Development Control
Ribble Valley Borough Council

Your ref: 3/2020/1037
Our ref:
Date: 15th March 2021

Re: Planning Application 20/1037

**Description: Proposed single storey building to be used as a holiday lodge and
creation of new vehicular access off Malt Kiln Brow.**

CLIENT: LIFESPACE CABINS				
PROJECT: SEED HILL CHIPPING PRESTON				
DRAWING TITLE: PRELIMINARY ACCESS PROPOSALS - SITE SECTIONS				
DATE CREATED: JULY 2020	DRAWING SCALE: 1-100	DRAWN BY: MWJ	CHECKED BY: -	QA CATEGORY: 1
DRAWING REF: TC / T19581 / 20 / 101				REV: A

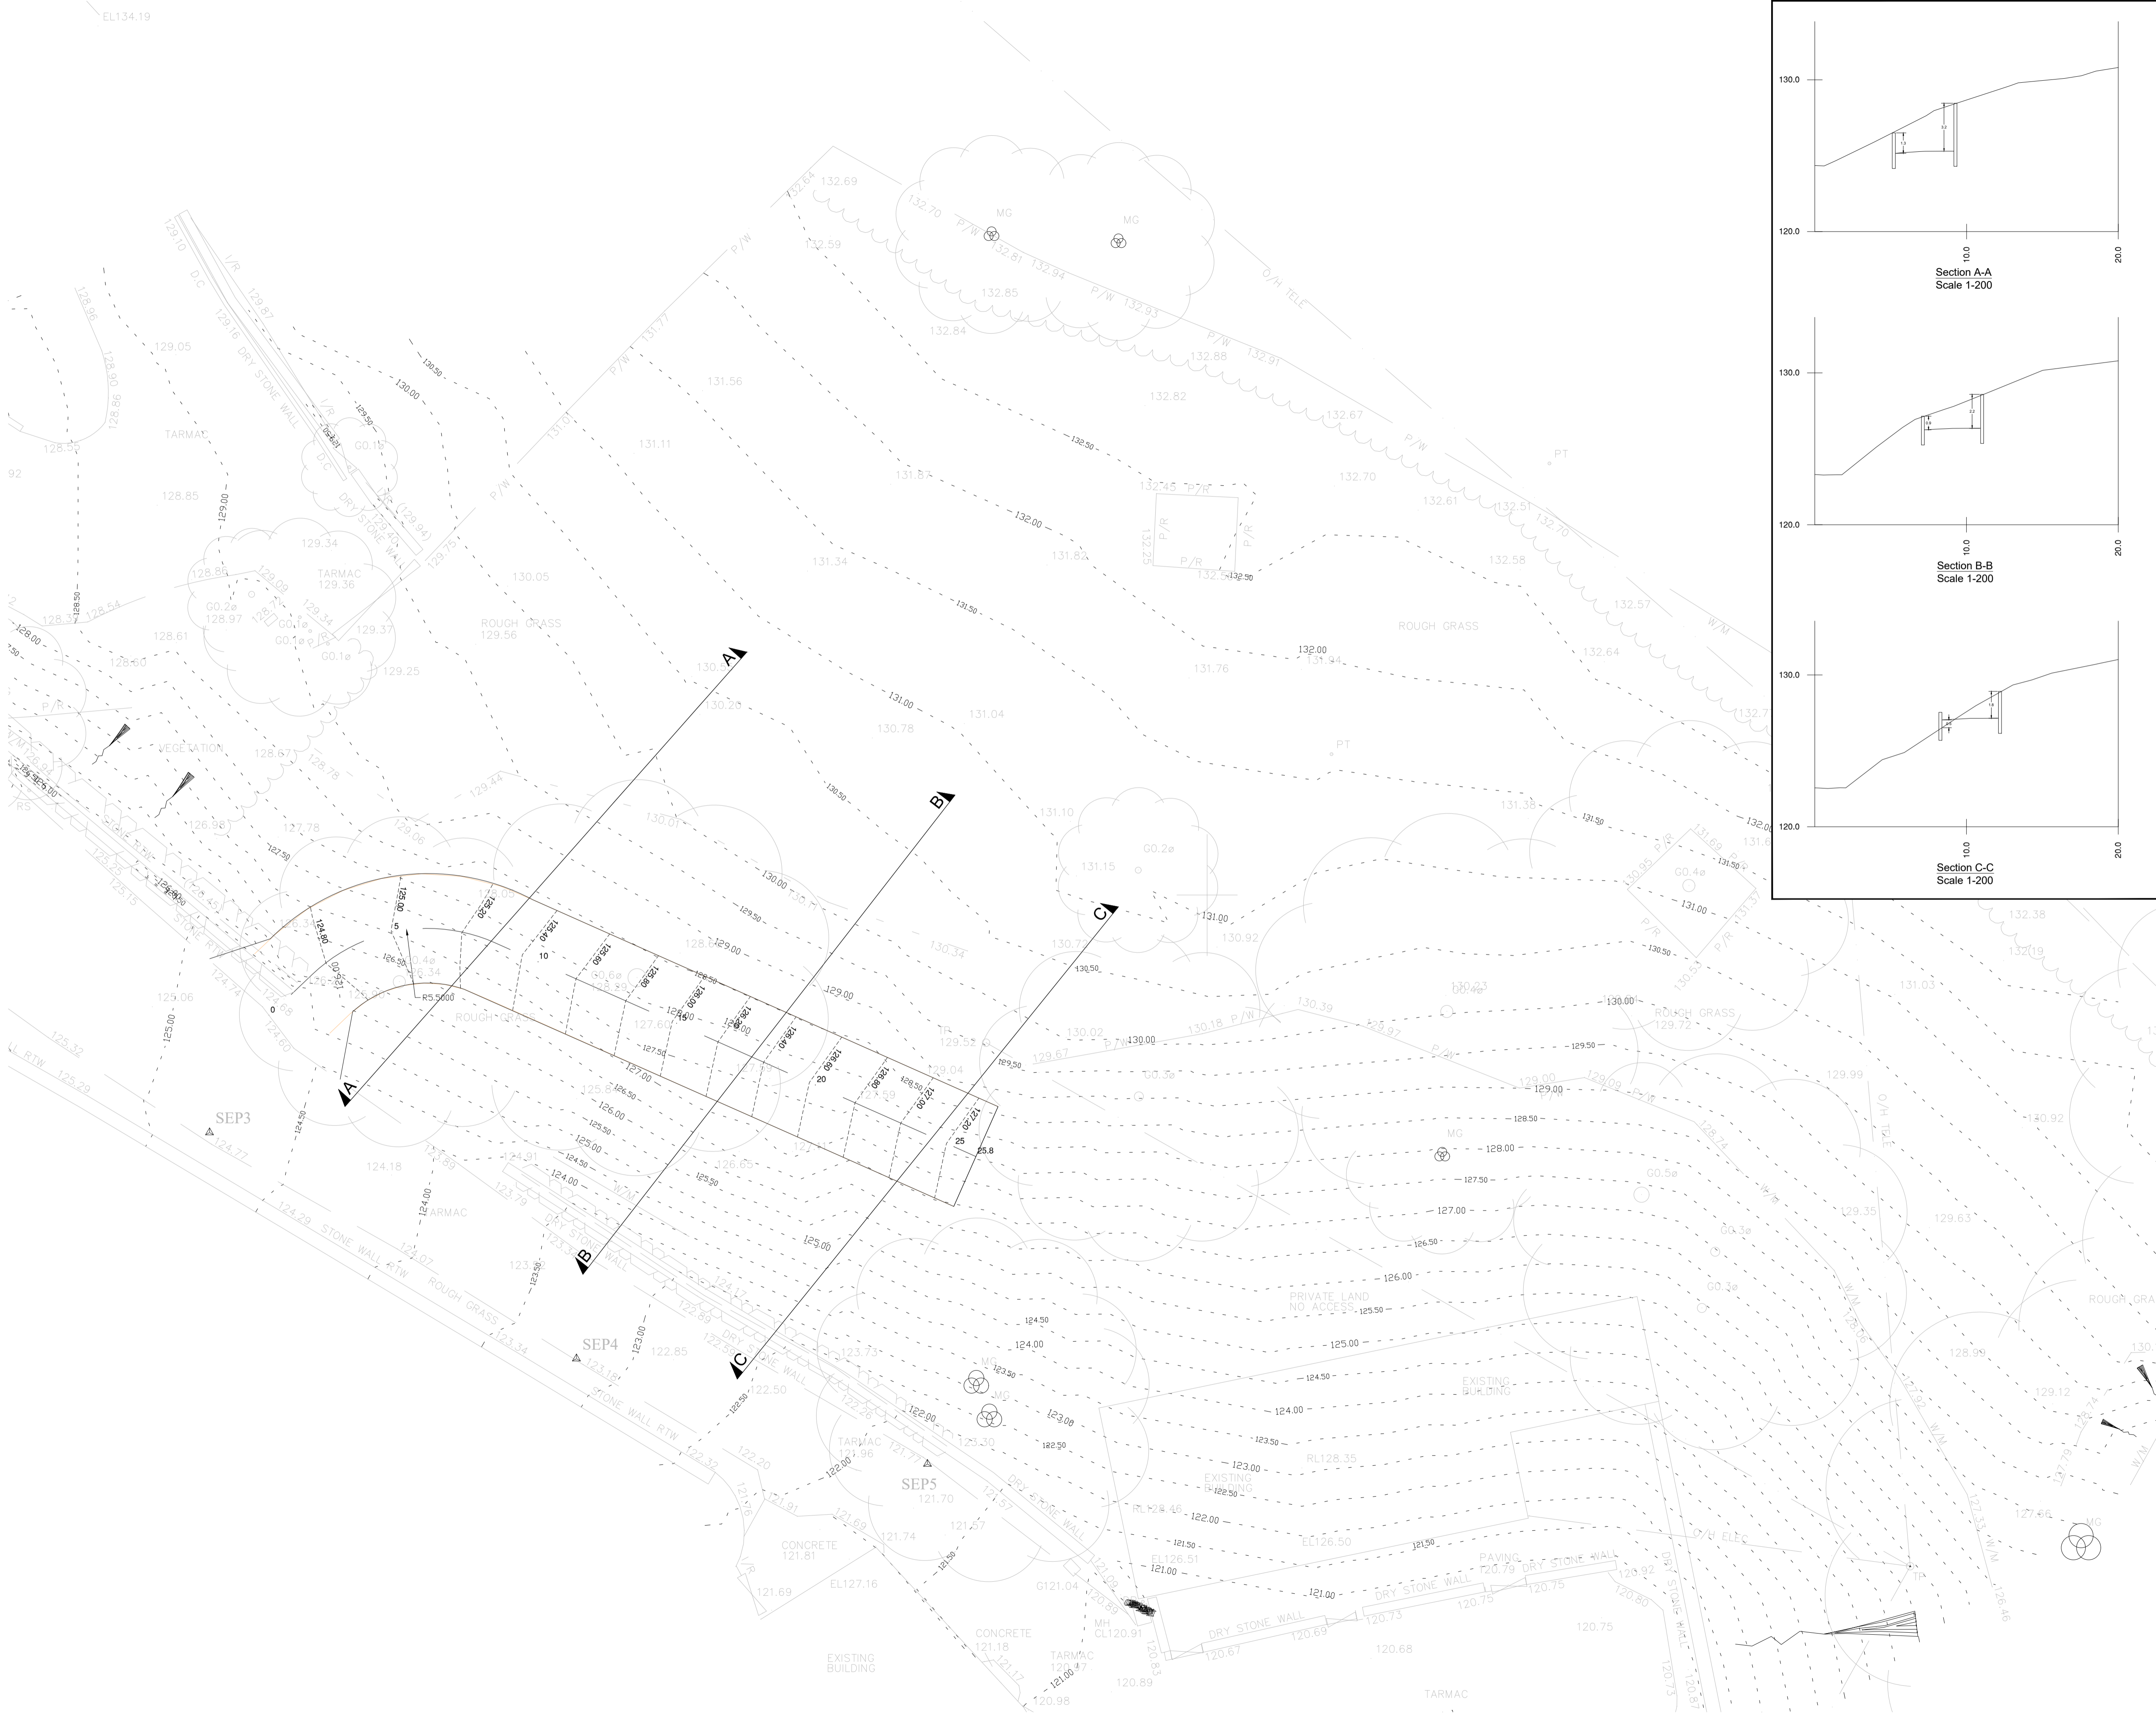
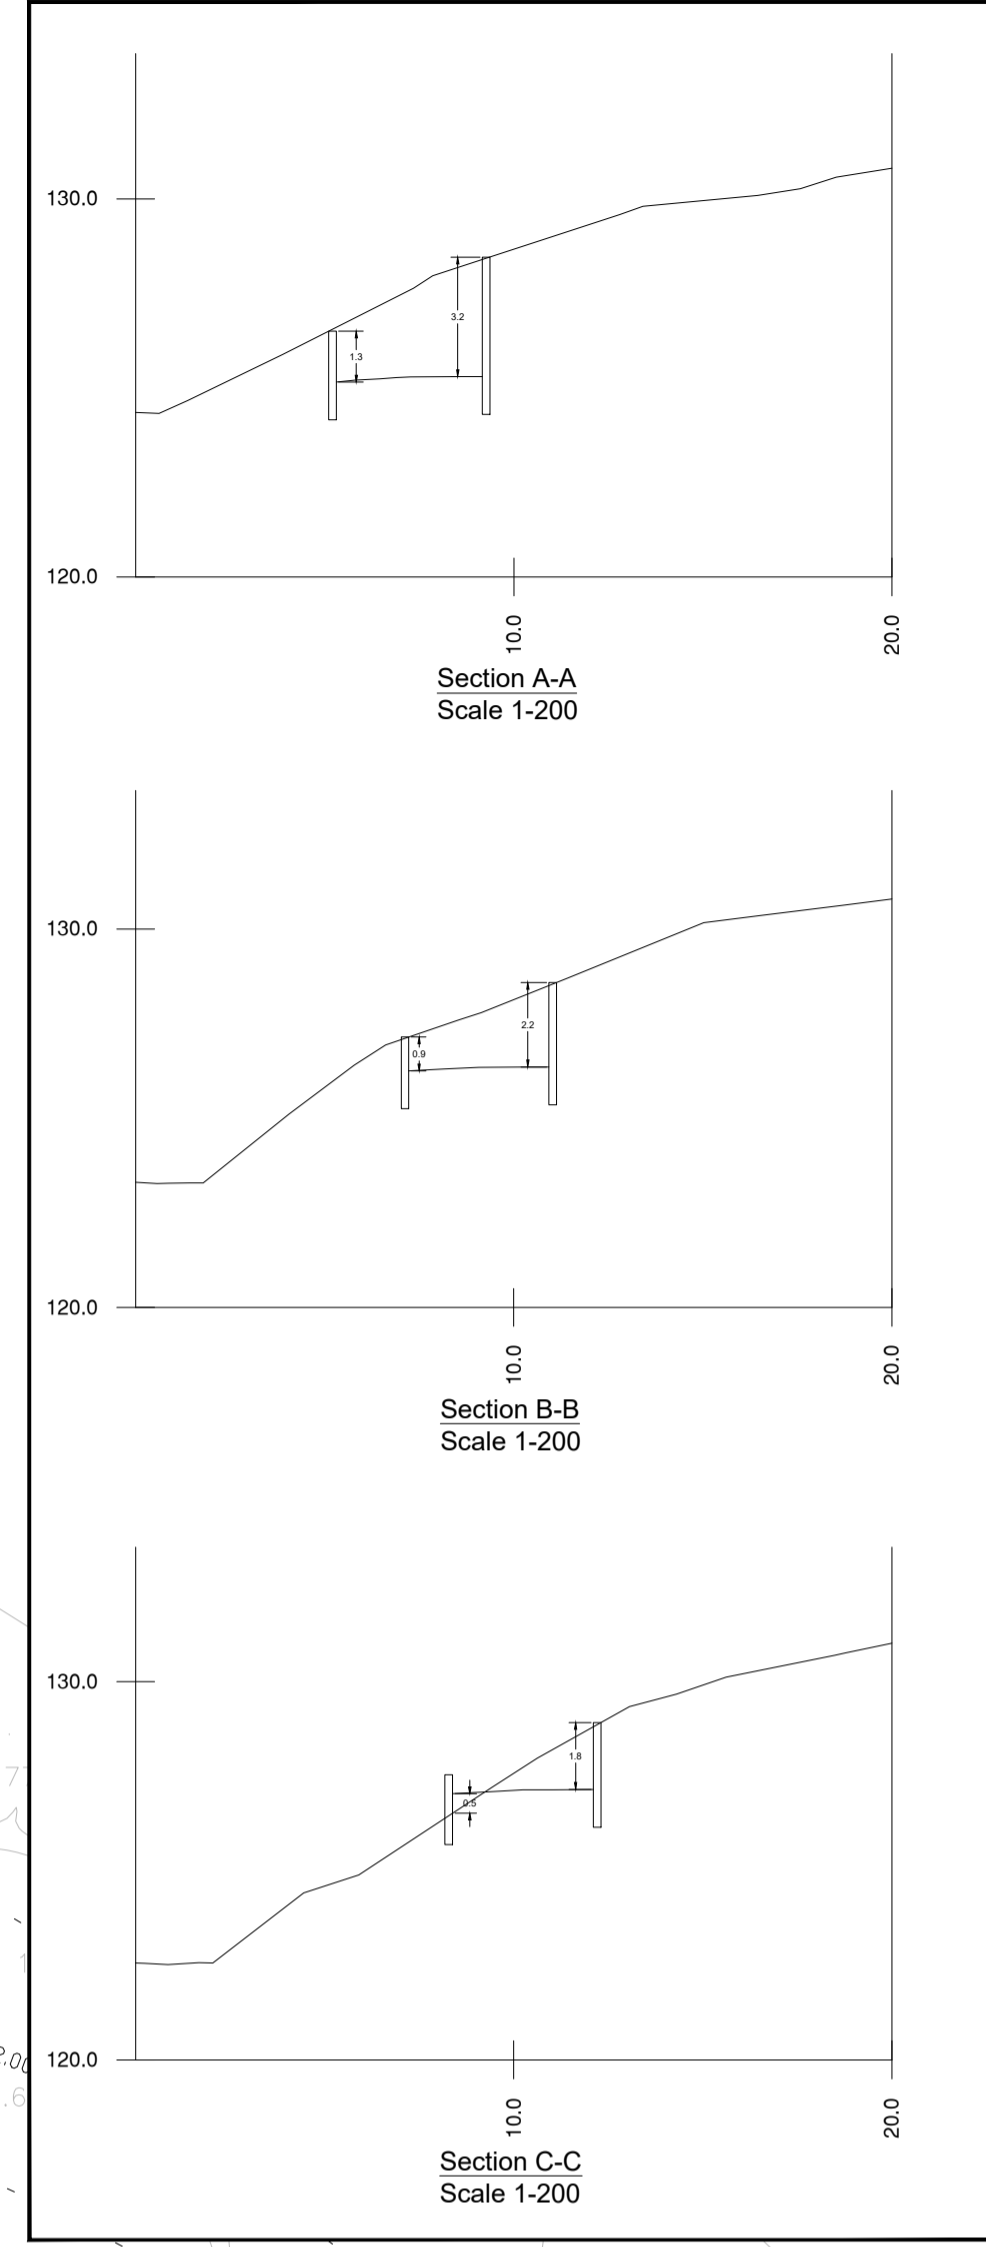
Seed Hill is a classified road and any new access should be constructed in such a manner to allow a vehicle to enter and exit the site in a forward gear due to the lack of forward vision. It is not apparent from the plans provided that the required visibility splay 2.4m x 43m can be achieved and that the retaining wall and ground to the rear of the wall will be lowered to a height of less than 0.95m to enable the safe exit from the proposed access.

The access is to involve the removal of a section of highway retaining wall prior to any work commencing on site full construction of any works adjacent to the highway will be required including details of any structures required to retain the land adjacent to the highway.

In order to progress the application further plans showing that a vehicle can enter and exit the site in a forward gear will need to be provided. A plan showing the

visibility splay will also be required, this will also need to take into account the fall of Seed Hill a drawing showing the profile of the road would be expected.
